# CITY OF PORTLAND, MAINE

July 22, 2015

Project Name: **Bangor Savings Bank Bank/Office building with two lane drive-through**  
Project ID: #2015-080  
Address: 20 Marginal Way CBL: 113 A 025001  
Applicant: Wendy Durrah, Bangor Savings Bank  
Planner: Jean Fraser

# PLANNING BOARD REPORT PORTLAND, MAINE

EXTERIOR ELEVATIONS

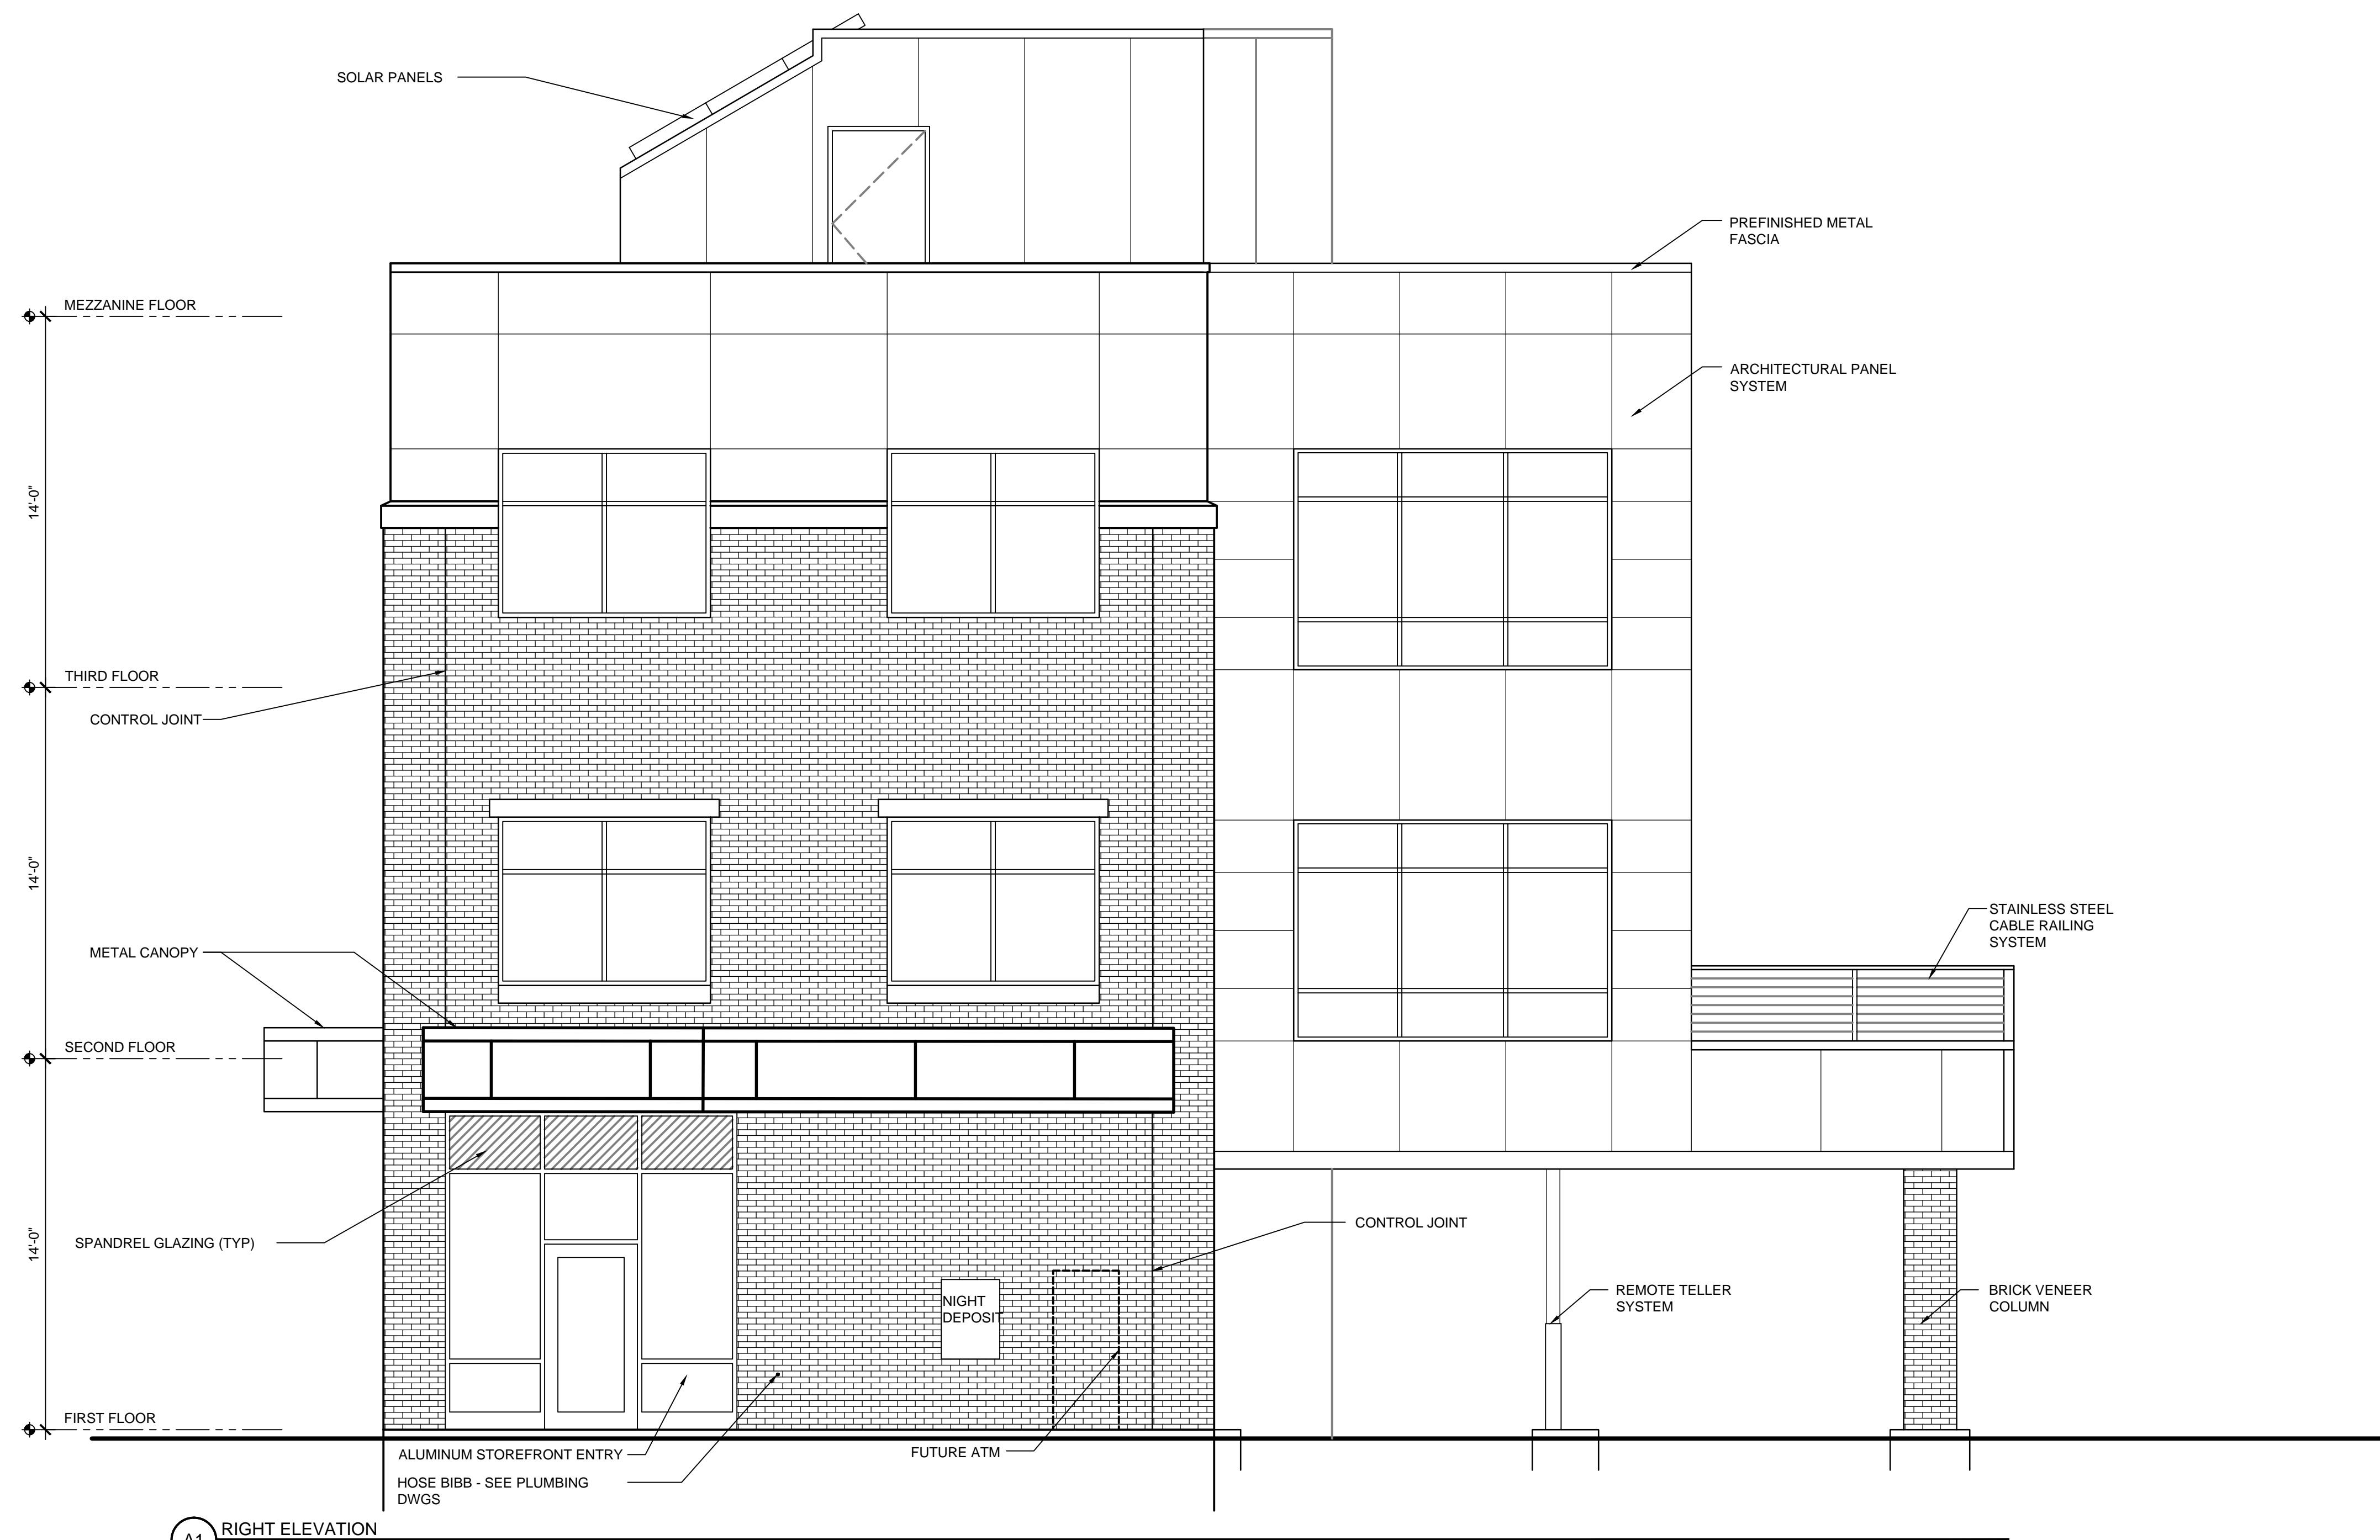
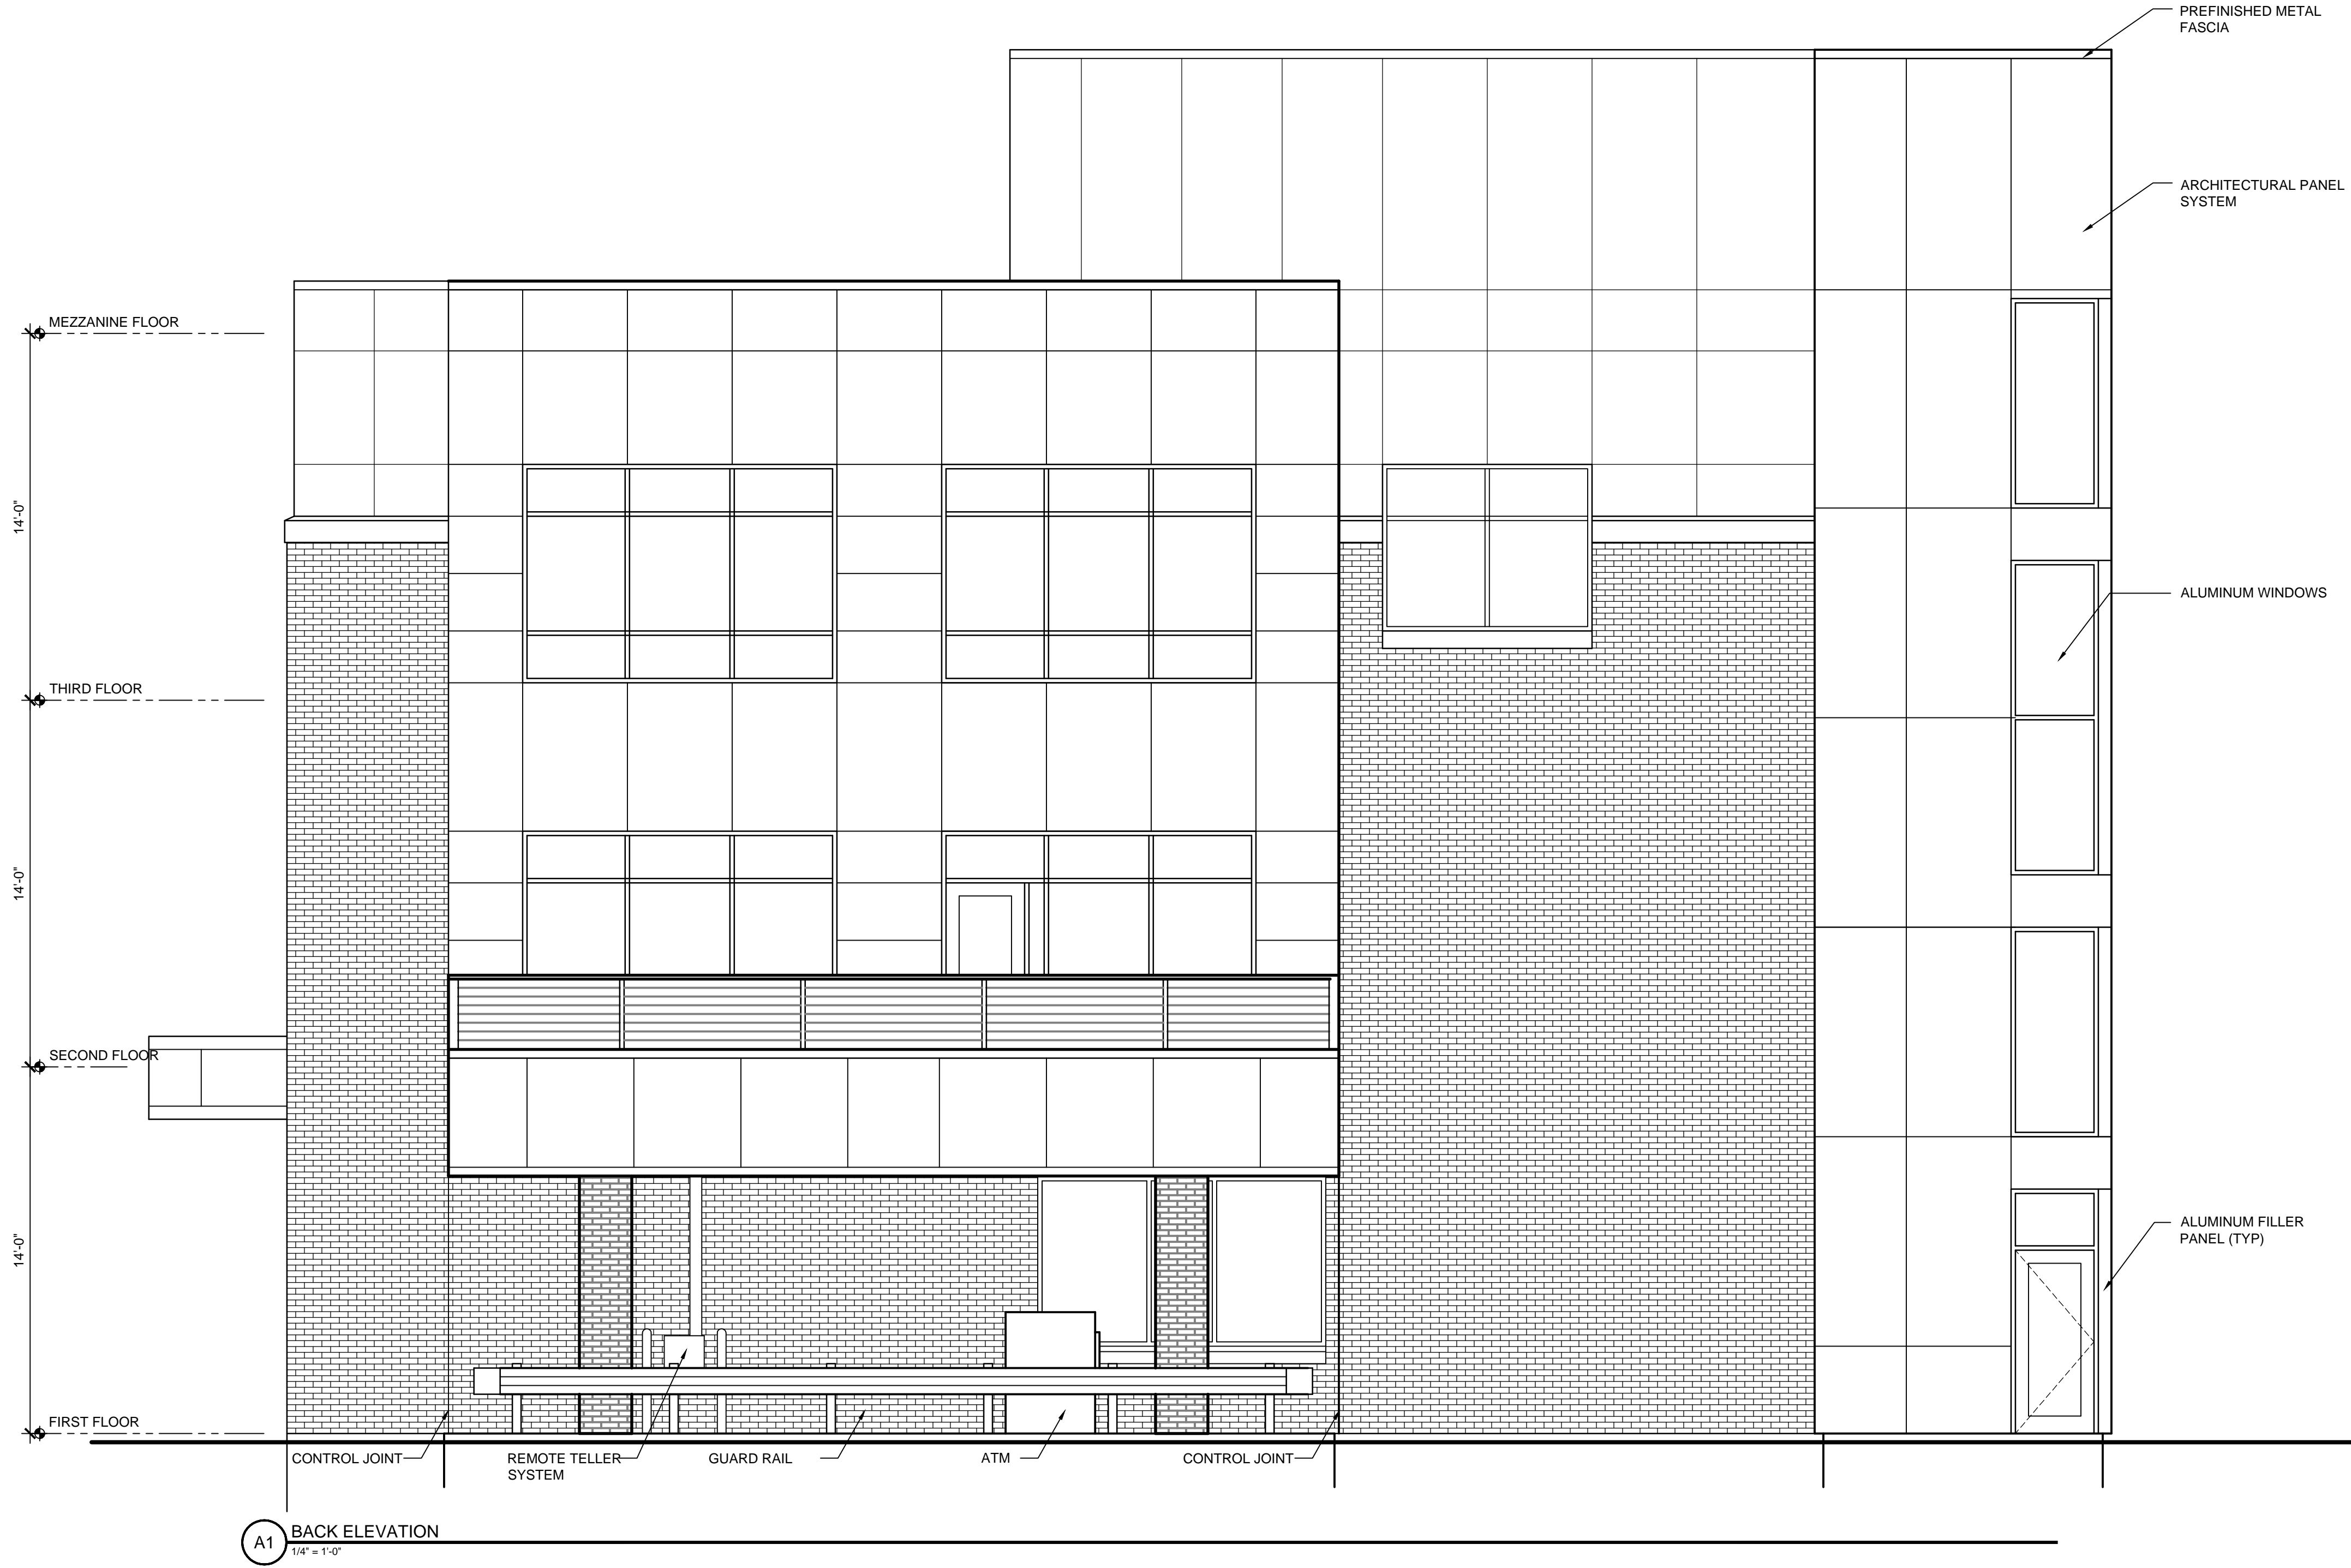
- **Proposed glass has a VLT of .56 which is lower than the allowed .7. A sample is required** before staff can assess whether the transparency is adequate.
- **Spandrel glass (opaque) is proposed** for the upper portion of the ground floor storefront which is **not allowed by the Standard. See comments below.**

- **Proposed transparency does not meet the Standard.**
- **Spandrel glass (opaque) is proposed** for the upper portion of the ground floor storefront **which is not allowed by the Standard. Staff does not support the use of spandrel glass in this project. Staff recommends that the ground floor windows be reduced in height** (and the canopy subsequently lowered) and the area where spandrel glass is proposed be eliminated. Reducing the amount of glazing will also reduce the solar gain in the façade.

- **Proposed glass has a VLT of .56 which is lower than the allowed .7. A sample is required** before staff can assess whether the transparency is adequate.
- **Proposed glass has a green tint** which is not allowed by the Standard. **Glazing should look clear. A sample is required** before staff can assess whether the color is adequate.
- **Spandrel glass (opaque) is proposed** for the upper portion of the ground floor storefront **which is not allowed by the Standard. See comments above.**

- ii. That the Planning Board has established that the maximum level of parking is 24 parking spaces; and
- iii. That the applicant shall reconsider the window design, including transparency, color, and size, in consultation with the City's Urban Designer, to meet the intent of the B-7 Design Principles and Standards. The final design to be reviewed and approved by the Planning Authority prior to the issuance of a building permit; and
